Planning Officer: Anita Gardner

Planning Application Ref: A/51/18/PL

Location: Pound Place Roundstone Lane Angmering BN16 4AL

Description of works: Demolition of existing dwelling & erection of a 64 bedroom care home (C2 Residential Institution) with car park, landscaped gardens & access from Roundstone Lane. This application is a Departure from the Development Plan.

**TREE PROTECTION PLAN**

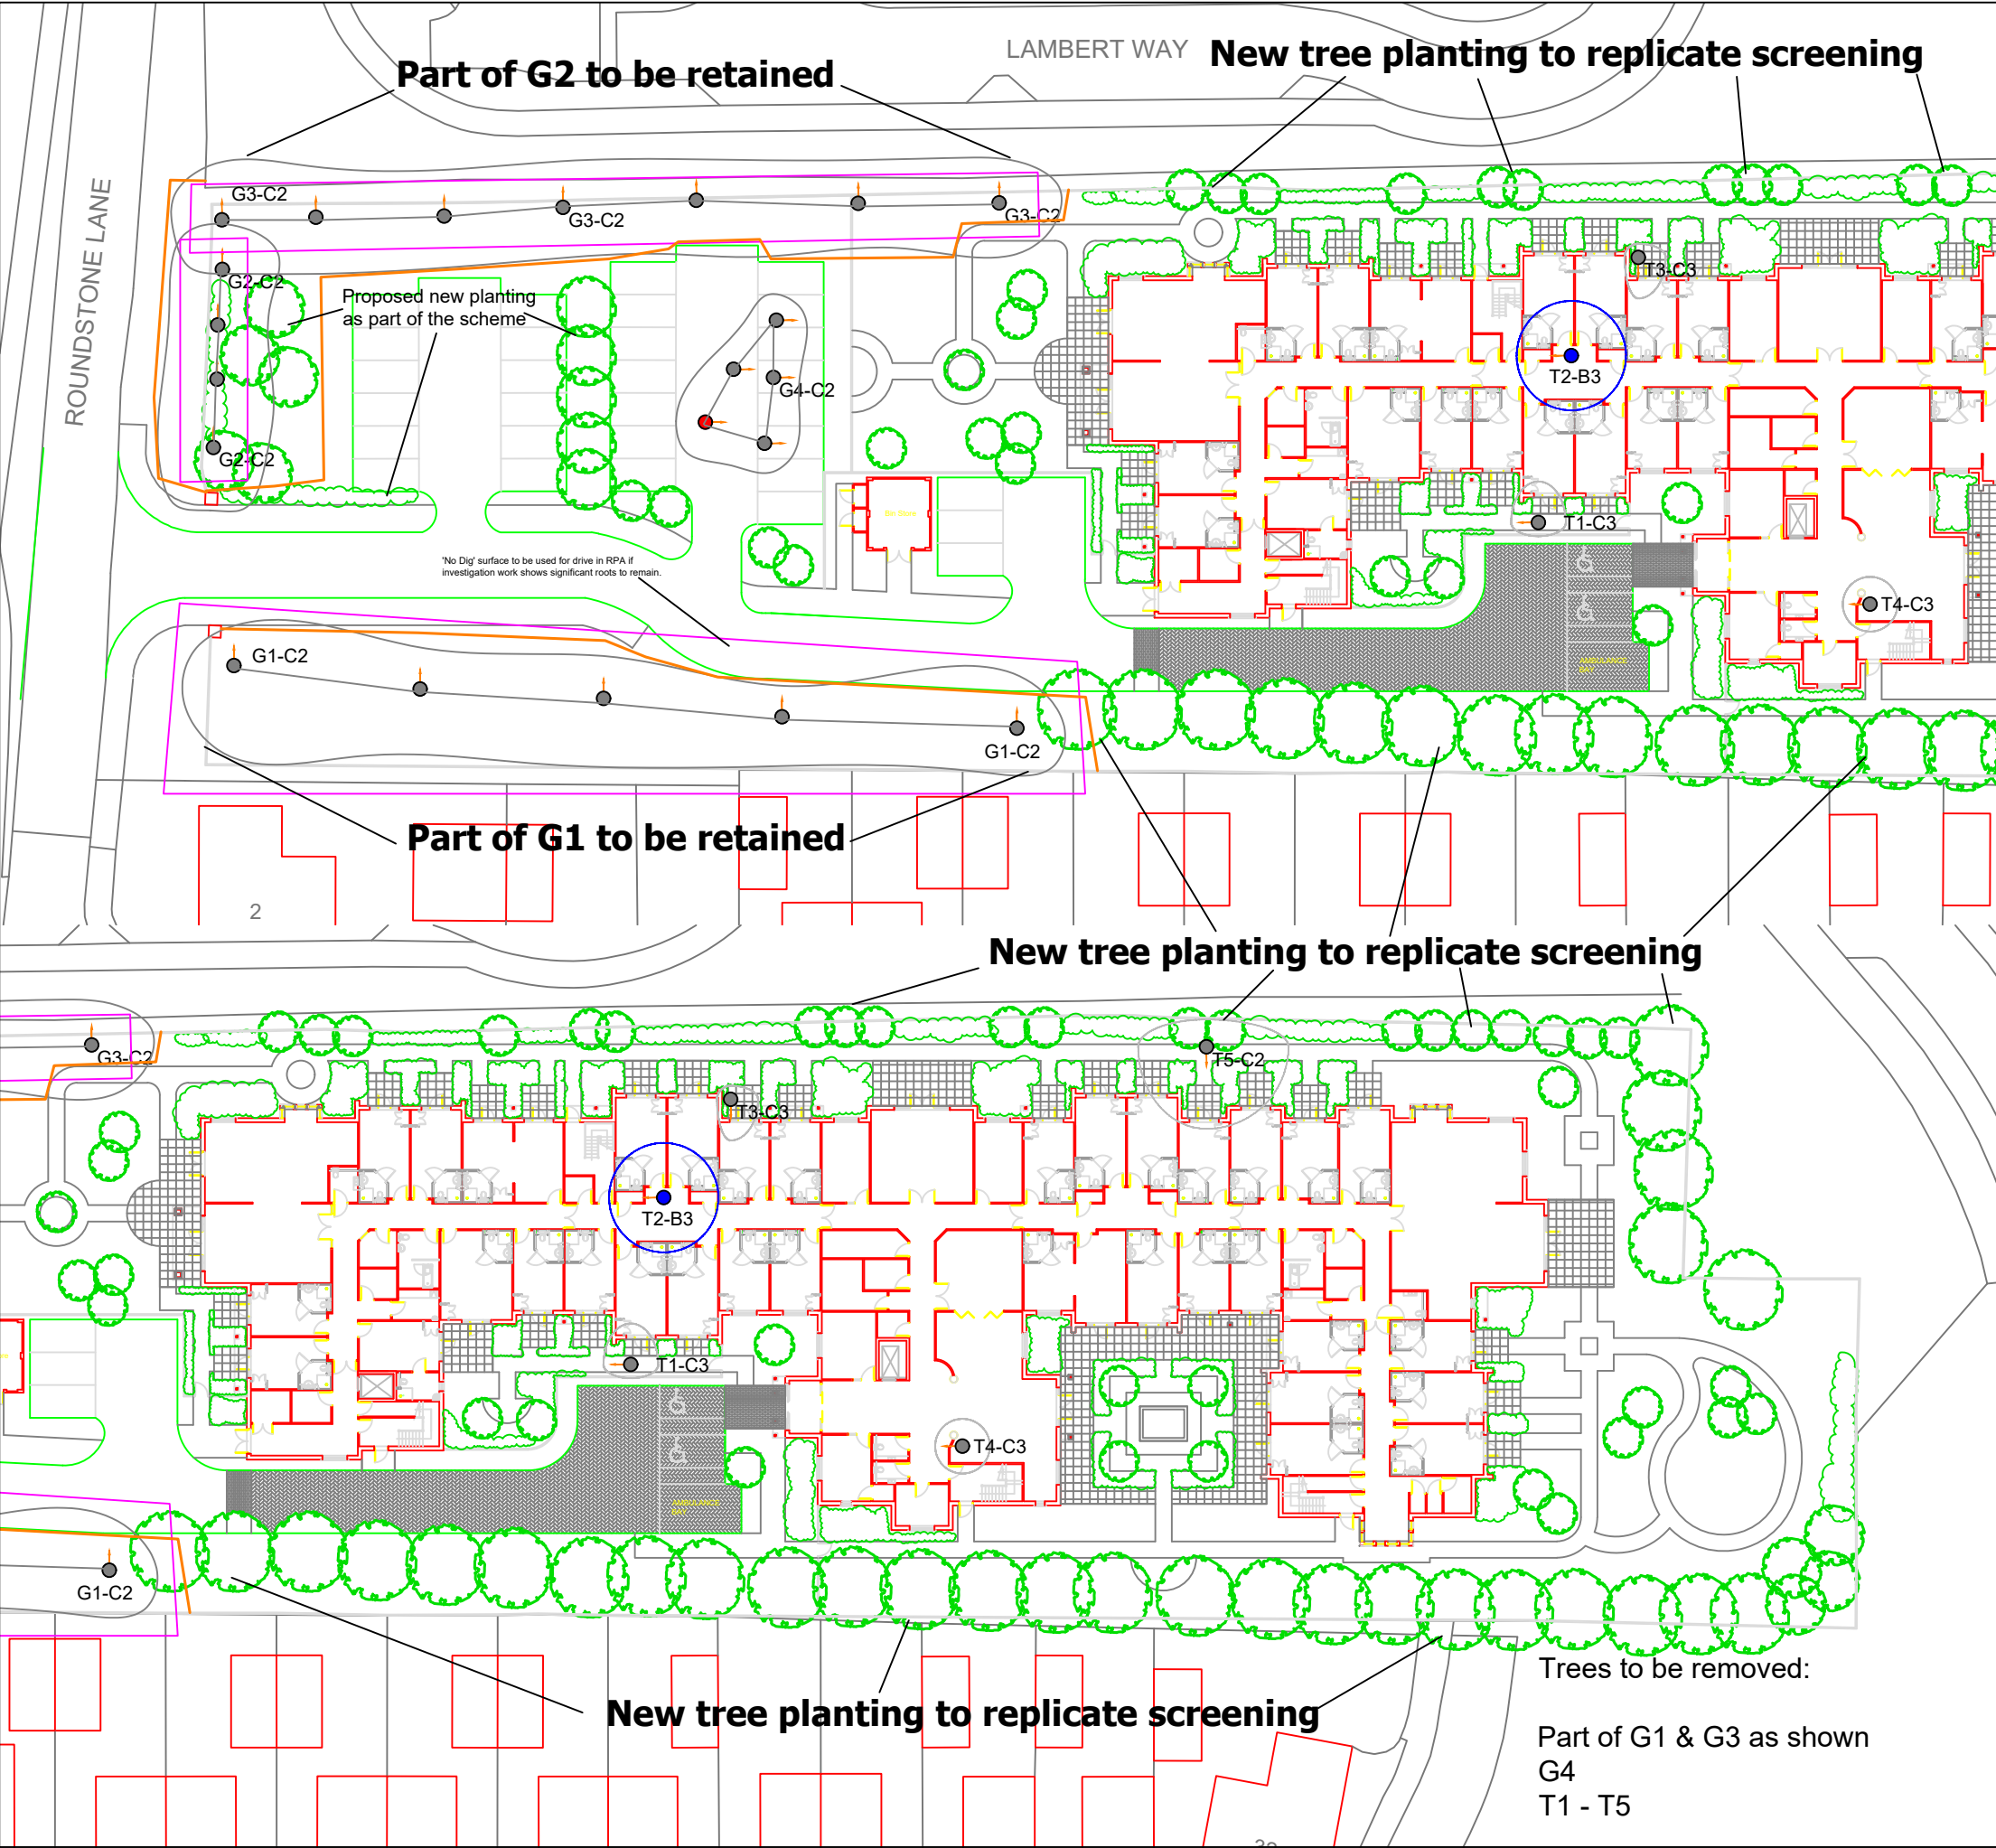
- I am pleased to note that superior tree group (G3) along the west boundary (adjacent Roundstone Lane) is to be retained. This will provide valuable screening throughout duration of any works and continue to add value to the street scene post-development.

- The proposal to reduce the height of tree groups G1-G3 incl. by 50% is excessive and would be detrimental to the ongoing health and vitality of these trees, such that their useful life expectancy would be significantly reduced. I accept that a degree of height reduction and trimming of lateral branches would be beneficial (to both mitigate the risk of future stem/branch failure events and improve conditions for adjacent dwellings) but suggest a maximum of 30% height reduction be proposed, where tolerable. A careful determination of any previous height reduction work should be made so that any further ‘topping’ does not create large wounds across parent stem diameter and is restricted to subsequent growth.

- On submission of a suitably detailed Landscape Plan and clear specification of tree pruning works proposed for each group (G1-G3 incl.), I would be able to recommend APPROVAL for this application, subject to the following conditions:

- Before the site is occupied or any machinery is introduced to the site or demolition work or construction work or alterations to existing ground levels takes place a **PRE-COMMENCEMENT Site Meeting** is to take place between the Arun DC Tree Officer and the Arboricultural Expert representing the site owners – at this meeting all protective fencing will be inspected to verify it is 'Fit for Purpose' as required under British Standard 5837:2012 and have been erected and positioned exactly as shown on the **Tree Protection Plan, dated 5th April 2018.**
